**Our Case Number: ABP-316119-23**

**Re: DART+ South West Electrified Heavy Railway Order - Hazelhatch & Celbridge Station to Heuston Station, and Hesuton Station to Glasnevin  
County Dublin and County Kildare**

**DART+South West (Zone D) River Liffey Bridge to Glasnevin Junction**

Figure 5-136 Zones D-2 & D-3: PPTBL & Glasnevin Cemetery Bridge Compound Haul Routes

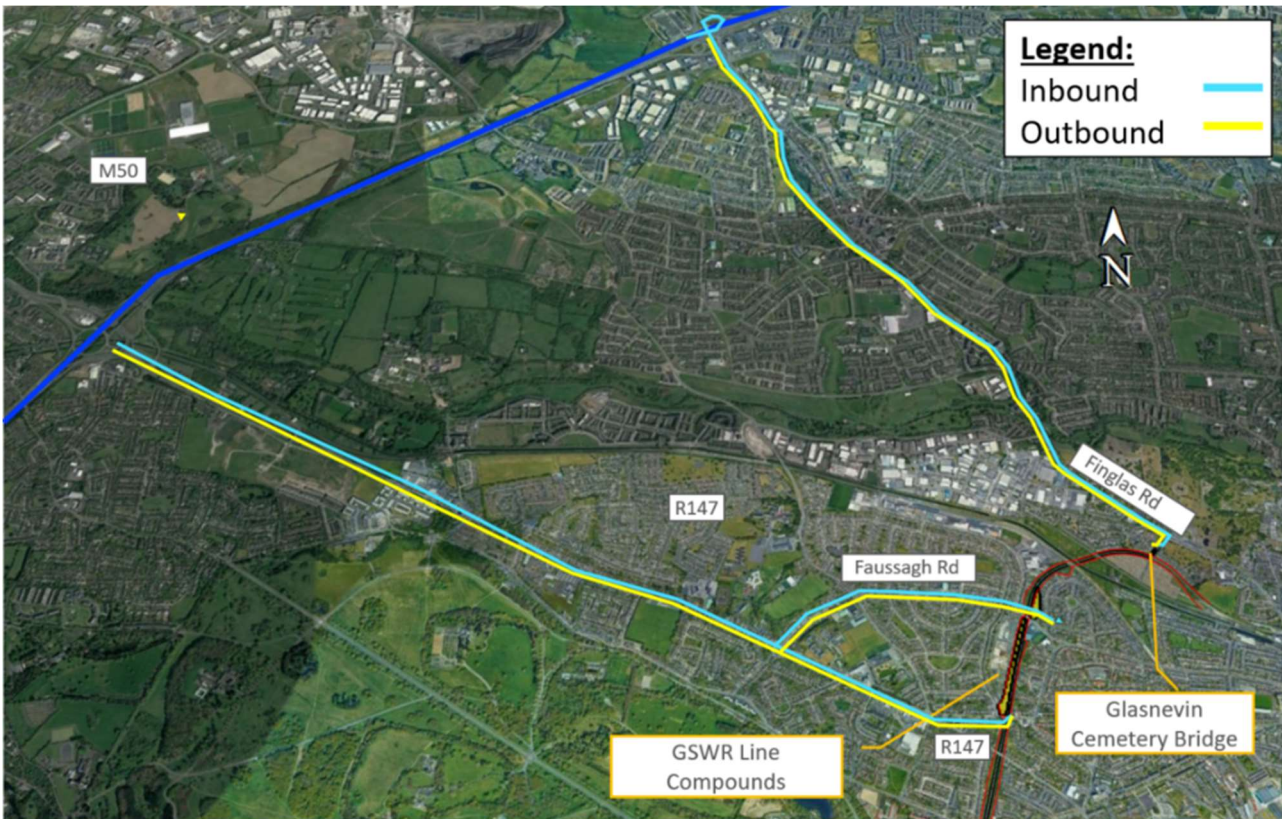
I understand that all this work will not be happening along the track that runs beside my house but there is a compound proposed in the car park of St Paul's cemetery. For the work to be completed material and machinery will be needed and this material will be stored in compounds.

The compound is situated at the entrance to two residential estates Claremont Lawns and Clareville Grove. At the end of Claremont Lawns Road is Clareville court, an elderly and independent living complex. This is the only entrance to enter or leave so all traffic must go this way.

It is not a good place for a works compound as there is too much traffic moving in and out of the entrance at Claremont Lawns.

There is a constant flow of public traffic coming in from both ways off the Finglas road. There will also be trucks and vans delivering material to the compound daily. Works machinery will only add to holding up residents' and the general public from getting in and out. The works is scheduled to run for 50 months (maybe longer) and that is a long time for residents to put up with this inconvenience. Has anywhere else being looked at for the proposed compound?

Glasnevin Industrial estate has many vacant warehouses along this line with big yards attached. Would this not be a better place to store materials and heavy machinery.

With any major construction project there is going to be dirt and dust and this needs to be managed. With having a proposed compound in the carpark of St Paul's cemetery materials and soil spoil will have to be stored there. Materials for to complete the works on the new bridge, temporary pedestrian bridge, material need to pin existing walls and banks, overhead line pylons (6-8 metres in length), removal of existing trees and shrubs, etc etc will all need to be brought in by vans and trucks. Soil spoil will have to be brought out by heavy trucks or dumpers. The surrounding roads will need to be kept clean of muck and stones. There will be prolonged haulage and tracked machinery

There is not off-peak time at the proposed compound at St Paul's cemetery. People will be coming to bury their loved ones or visit the graves of loved ones throughout the day. Deliveries will have to be managed by the main contractor and done in a way as not to have vans and trucks stacked up on the road waiting to load or unload. Residents must be free to move in and out as they need to. Many older residents in the area use the old folks centre situated at the end of Claremont Lawns for to get their dinner (Monday to Friday) and for day time entertainment such as music and bingo.

The proposed compound at St Paul's cemetery will take away the car parking spaces there as they will be needed to situate site offices, canteen, drying rooms etc etc. It will also be needed as a compound to store materials and machinery. Also, as a temporary bridge is being constructed to allow access to the graveyard, people will have to walk through this proposed compound or some of it will need to be fenced off to allow people and coffins by. People will need to visit the graves of deceased relatives and friends as well.
